GATWICK AIRPORT NORTHERN RUNWAY PROJECT (NRP): APPLICATION FOR ORDER GRANTING DEVELOPMENT CONSENT - FINAL SUBMISSION FROM HORLEY TOWN COUNCIL TO THE EXAMINING AUTHORITY (EXA)

Horley Town Council
8 March 2024

DRAWING NO.	REVISION
	FIGURE 4.2.1b	For ES Issue
	DRAWN BY	PM / CHECKED BY
	JM	KC

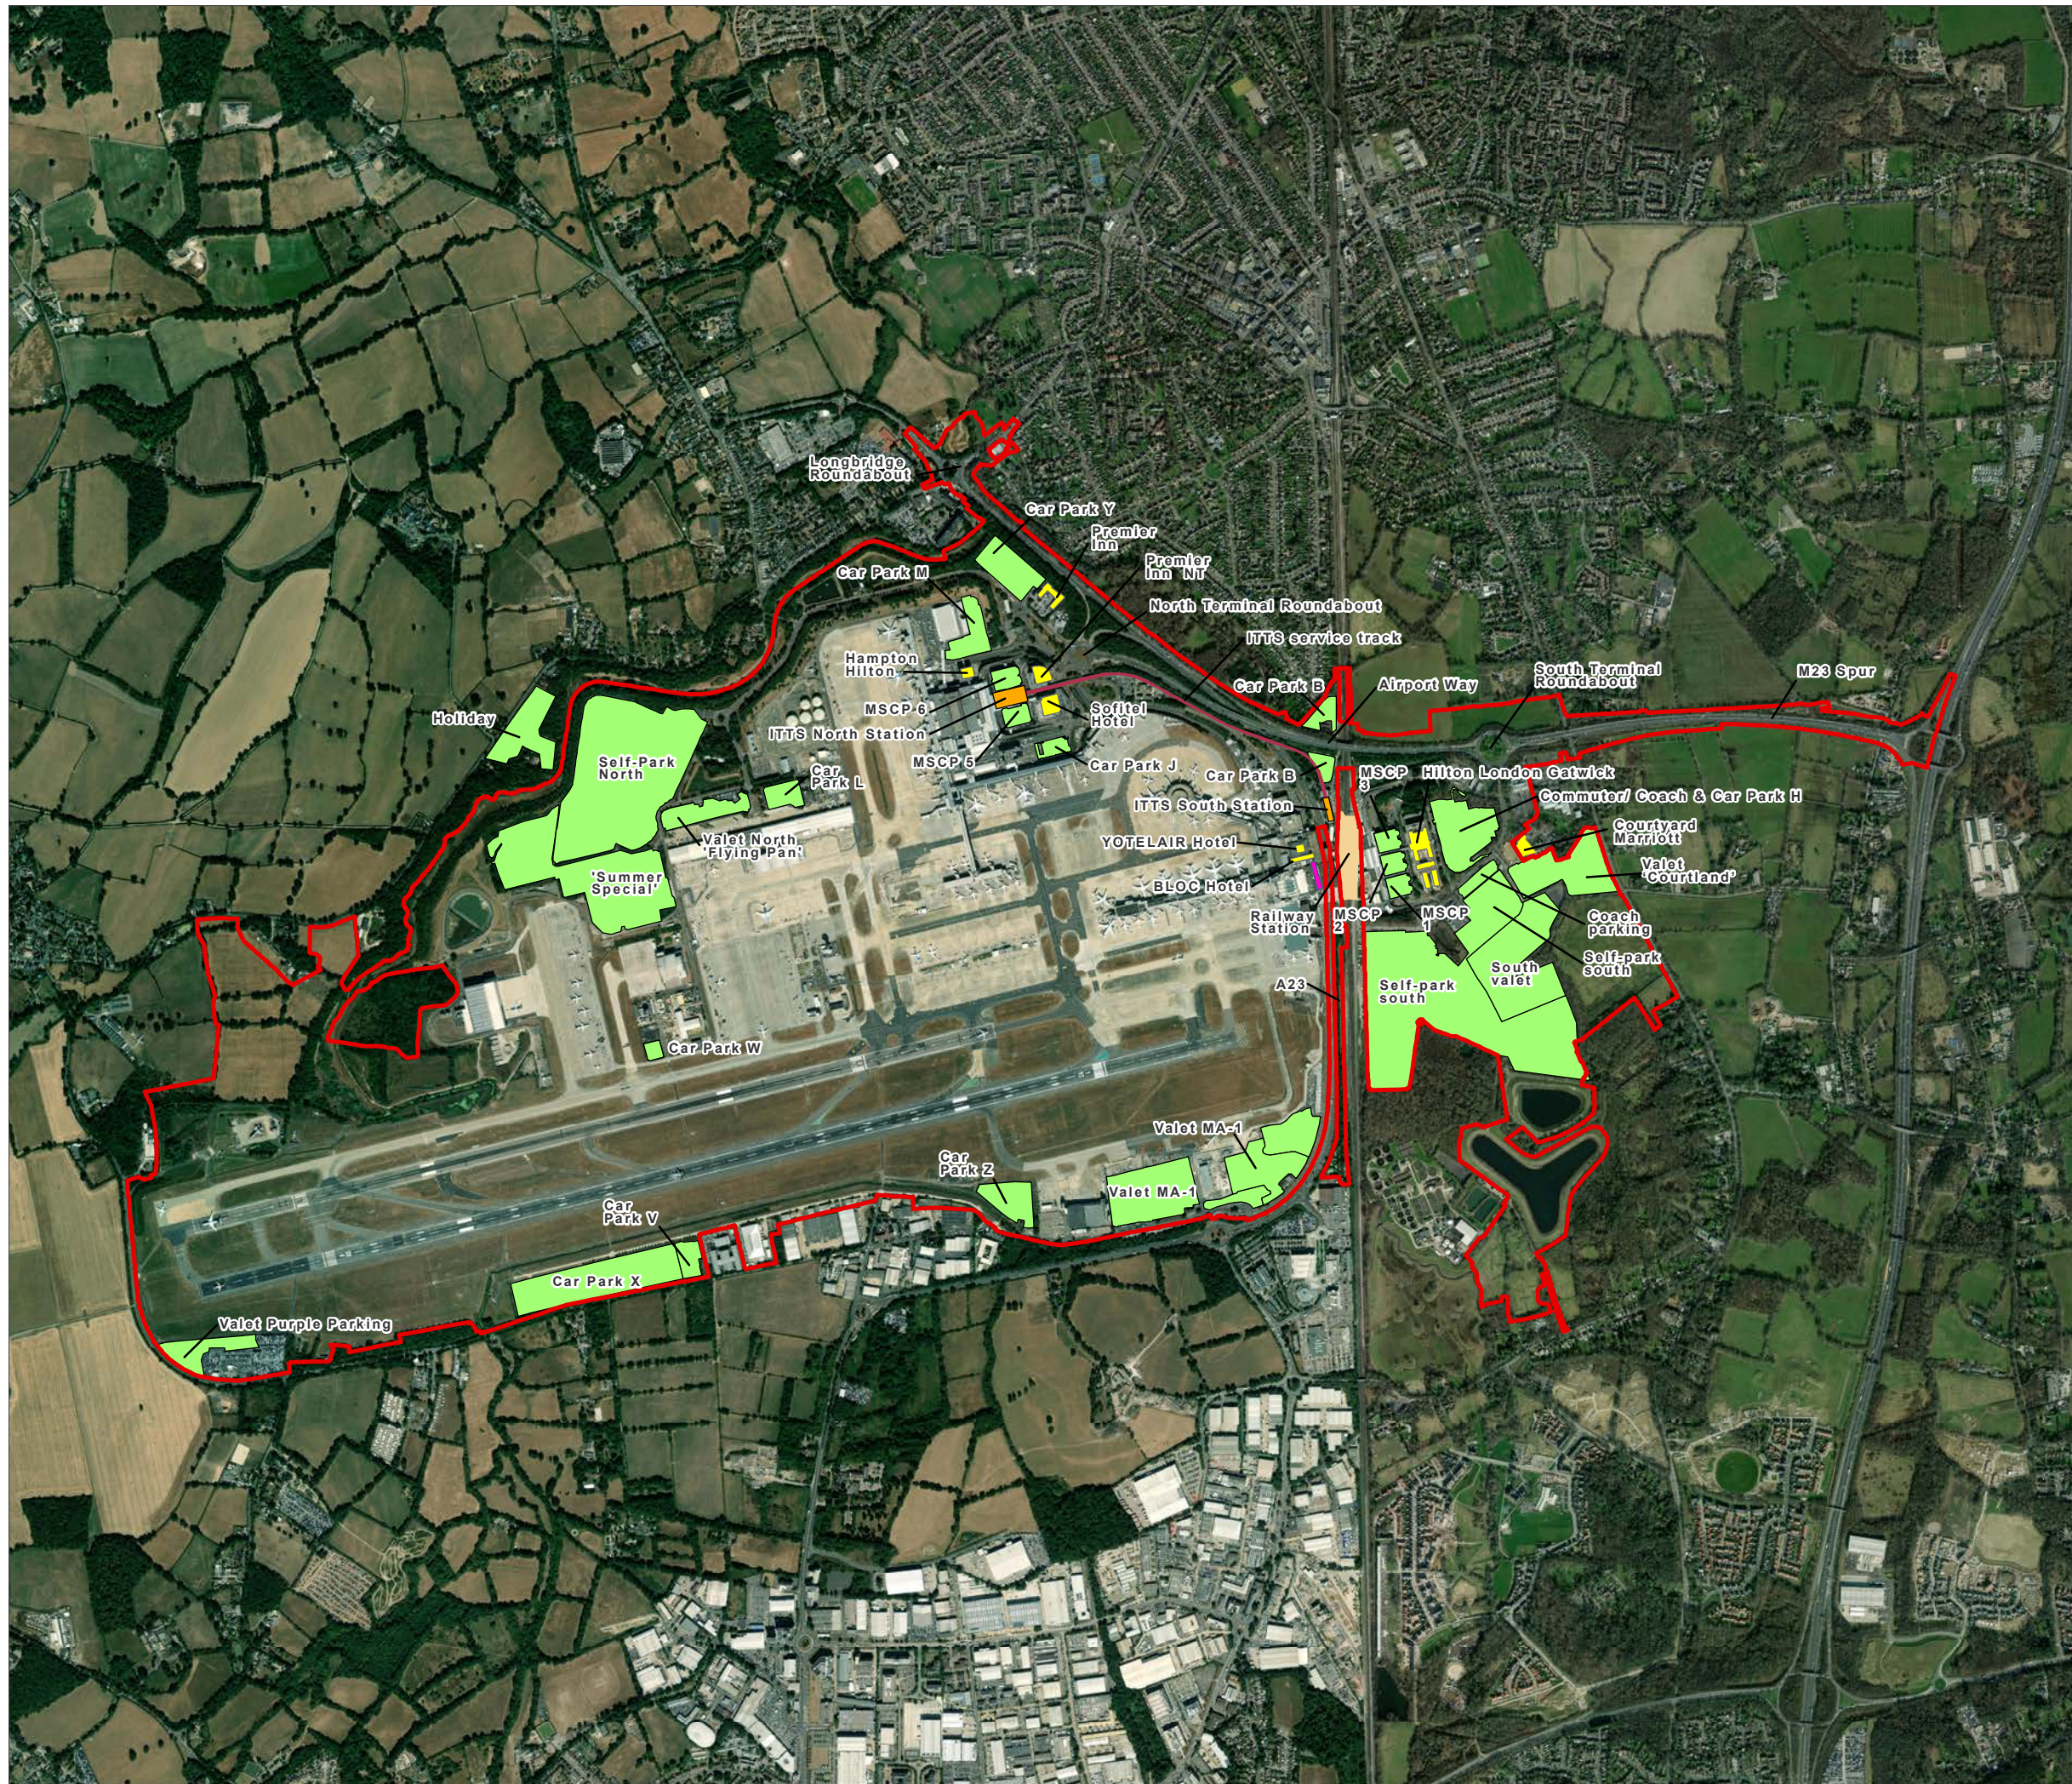
We have been informed that GAL plans to have a concrete crusher located in 'car park Y', off the northern perimeter road. There is however no reference to this in the DCO documents so, if the information is correct, we would request the following information:

1. The intended hours of operation.
2. Anticipated noise levels generated by this plant when in operation.
3. Anticipated noise levels for the residents in the Longbridge Walk area.
4. Assessment on noise impacts to the adjacent hotels.

We would ask that an alternative 'on airport' site be considered such as the former maintenance area to the south of the main runway which would have less impact on local communities.
